Located At 31 SUMAC ST

Job ID: 2012-04-3820-SF

has permission build a 26 by 32 foot Single Family Residence.

**RE:** Review Comments for Single Family Site Plan

**SITE PLAN**  
OF:  
**BRAASCH PROPERTY**  
25A SUMAC STREET  
PORTLAND, MAINE  
FOR:  
**CONSTRUCTION SYSTEMS OF NEW ENGLAND**  
5 REAR INDUSTRY ROAD  
SOUTH PORTLAND, MAINE 04106

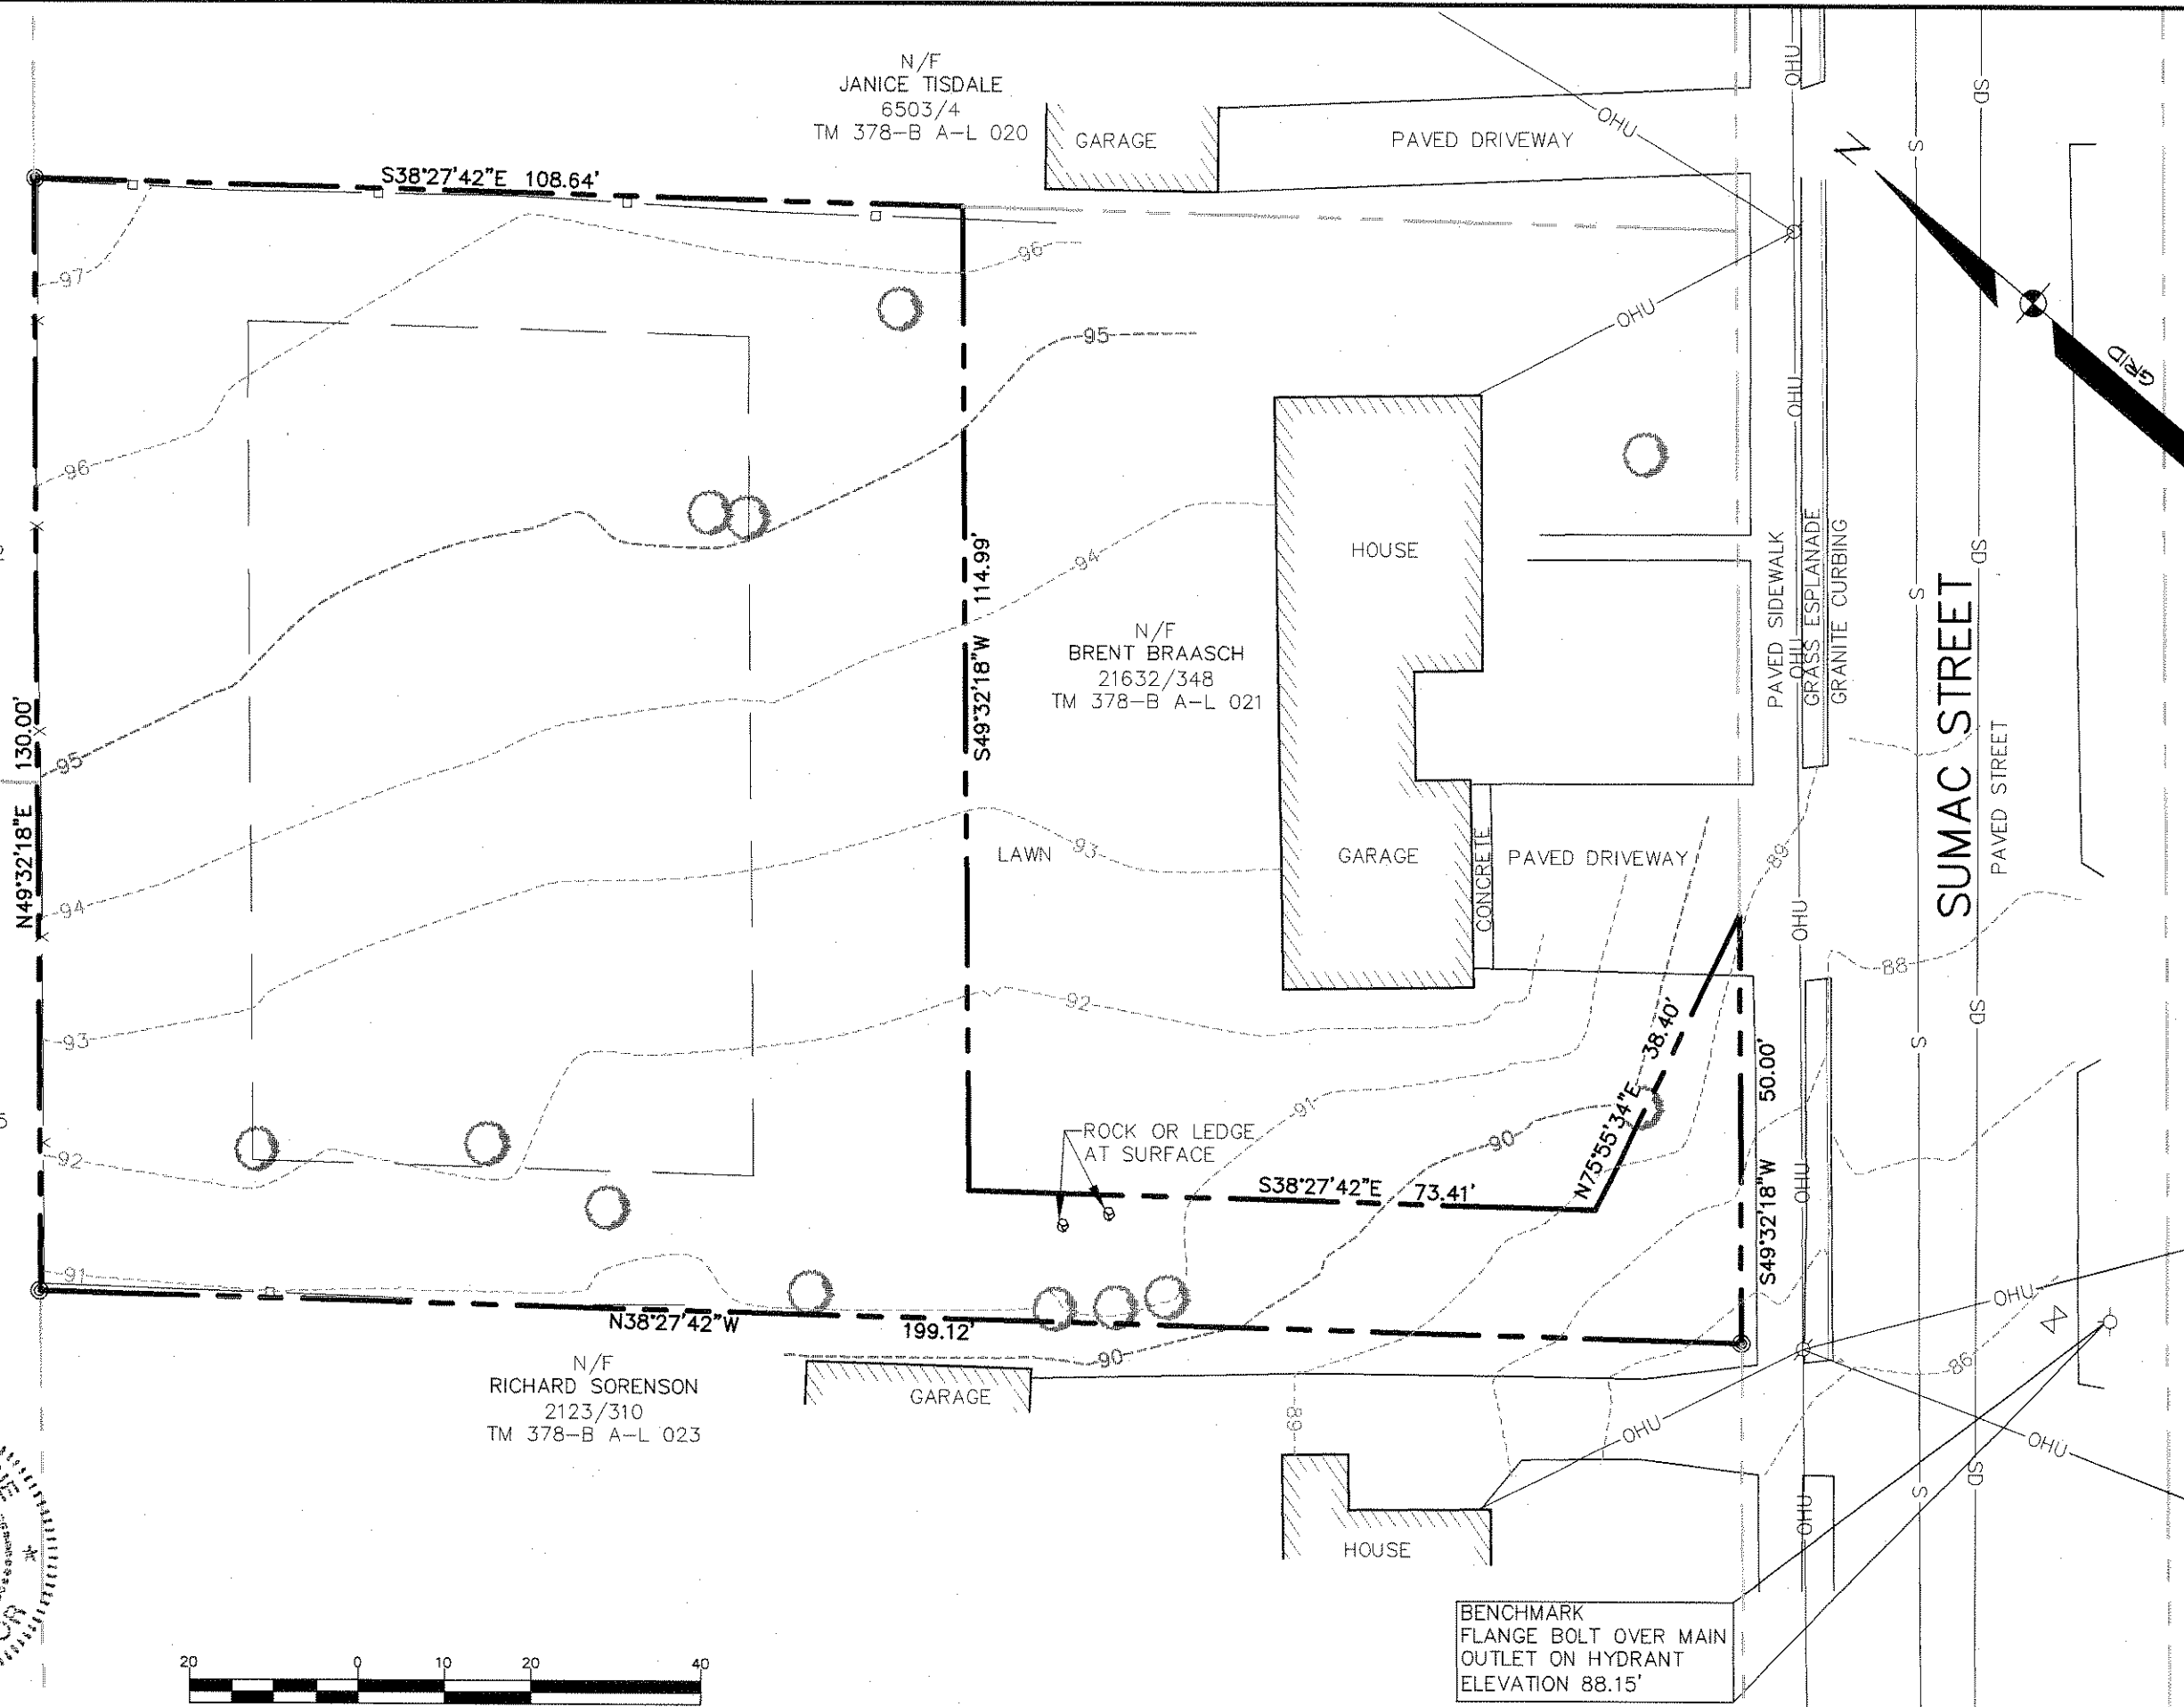
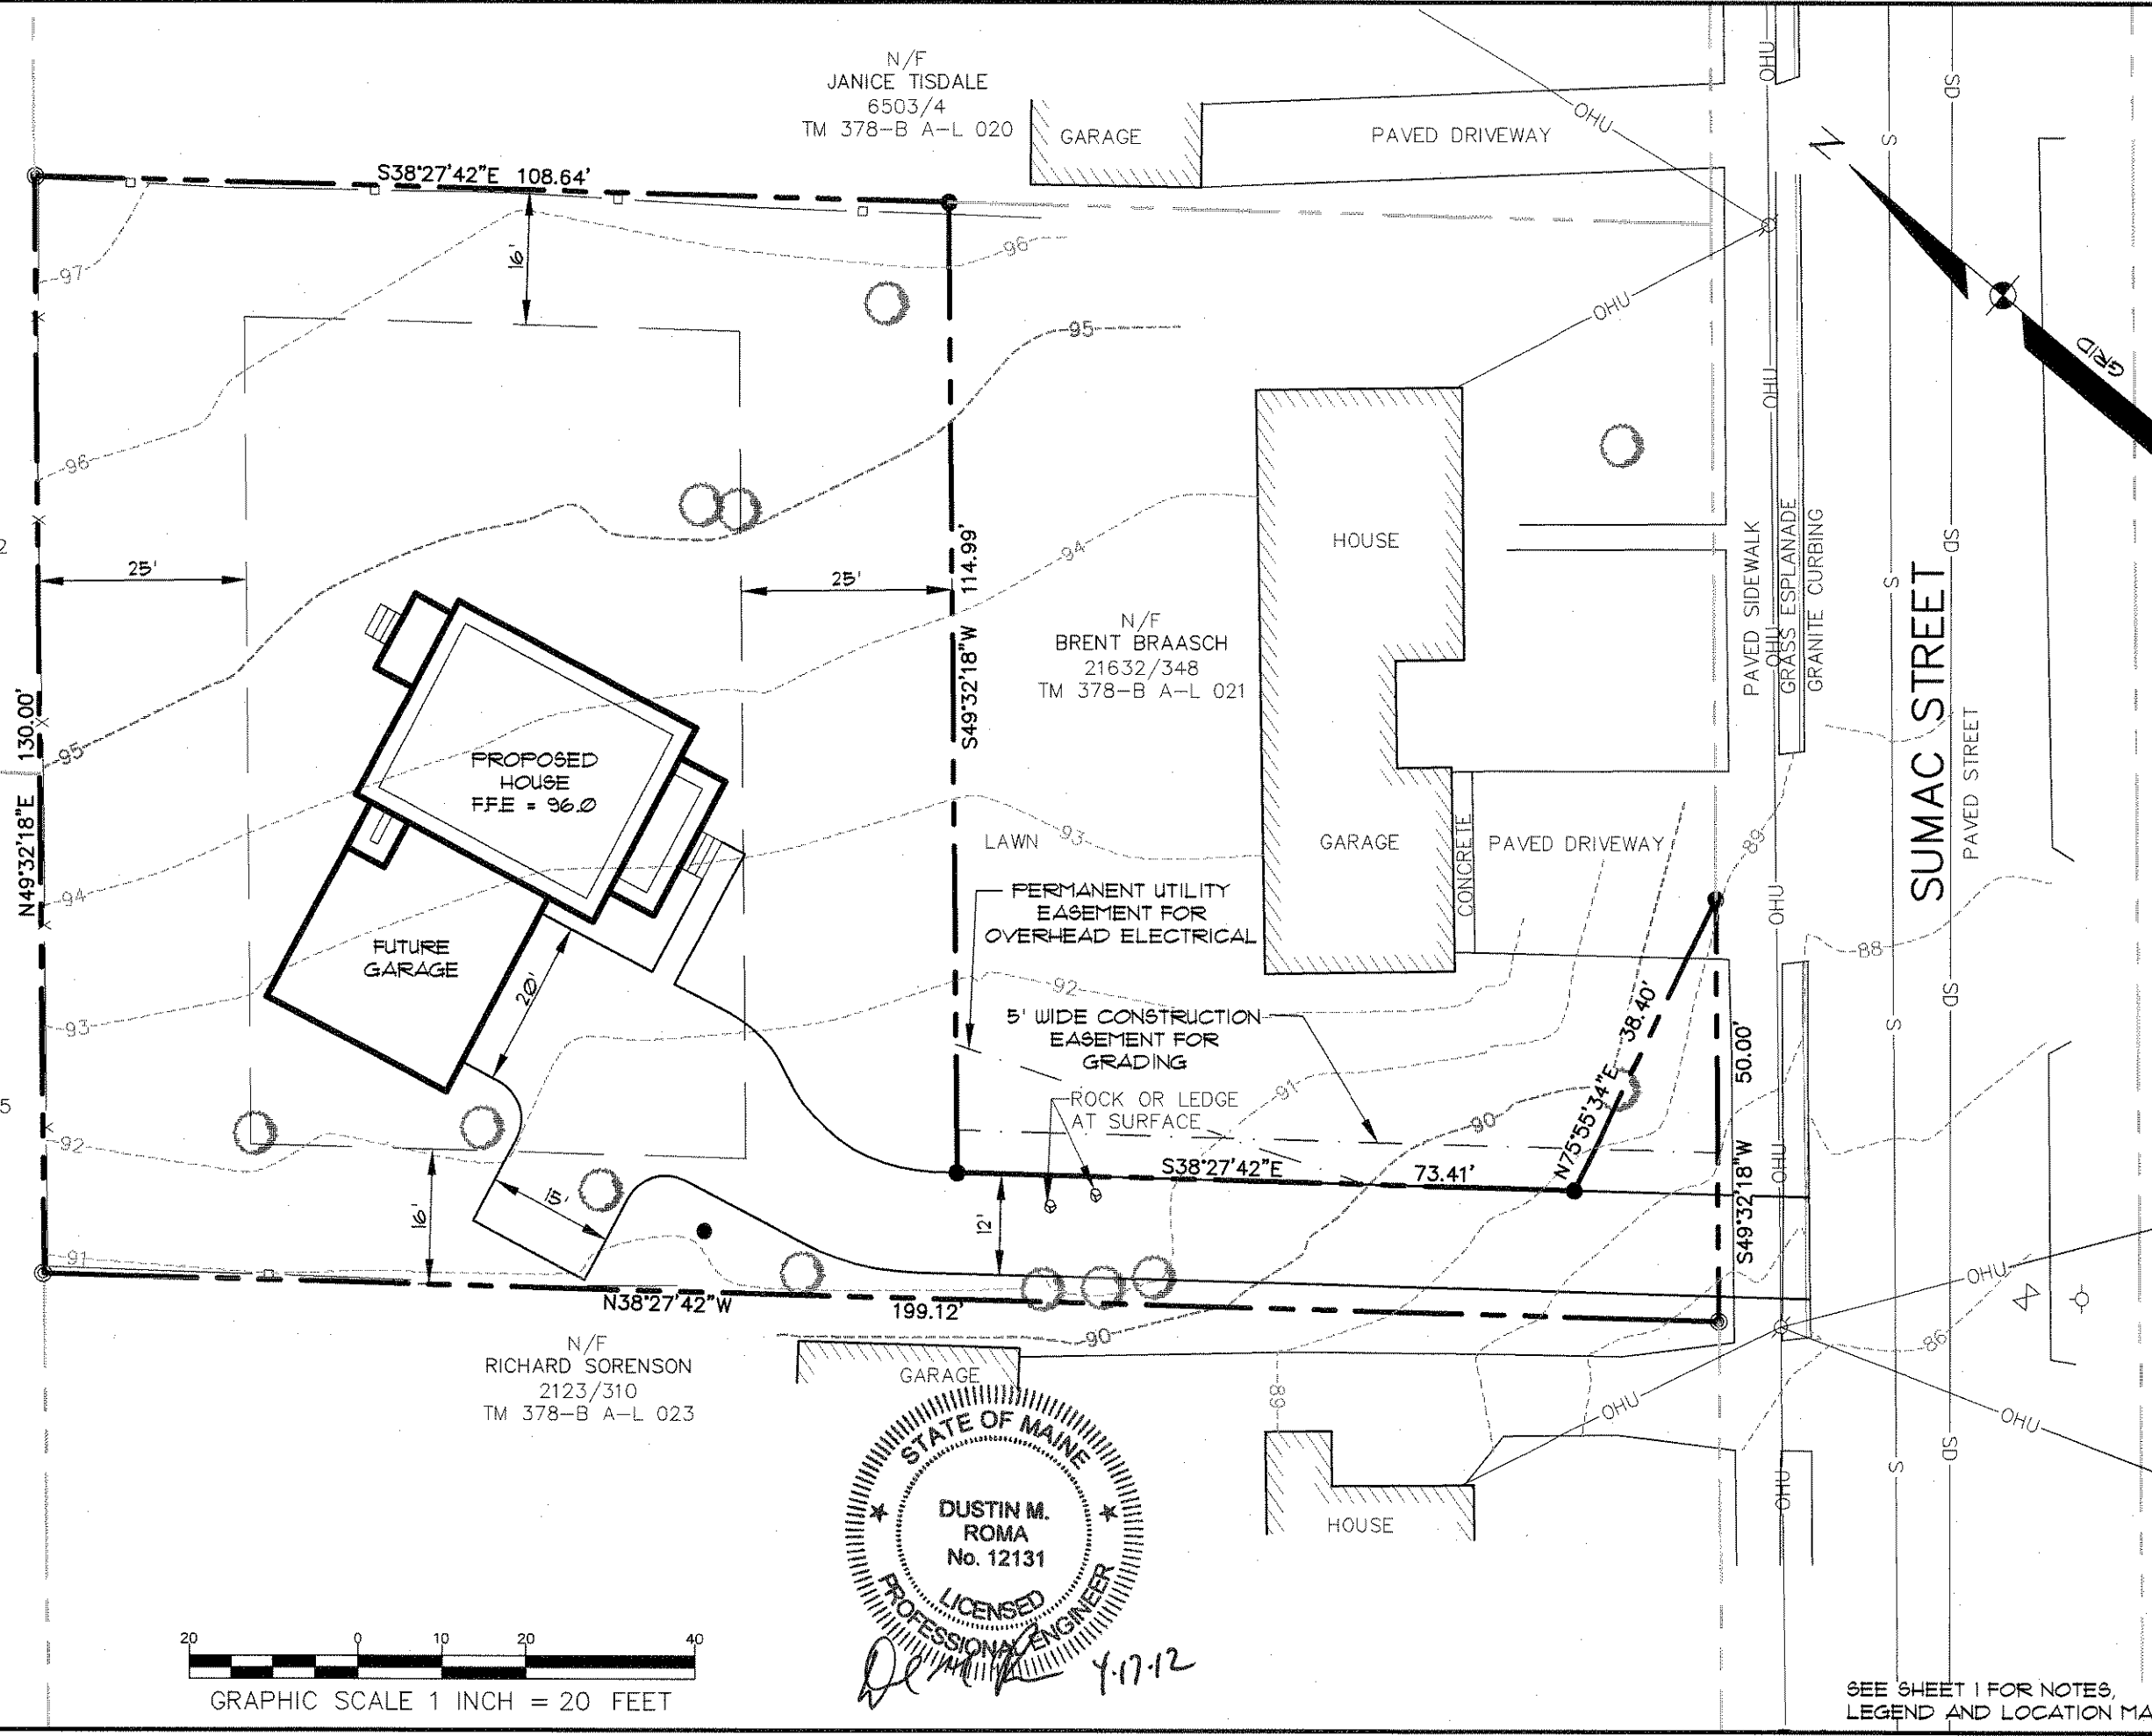
1. Please submit a revised site plan that includes the following information:
  - Please remove the garage footprint from the plan since it is not proposed to be built at this time.
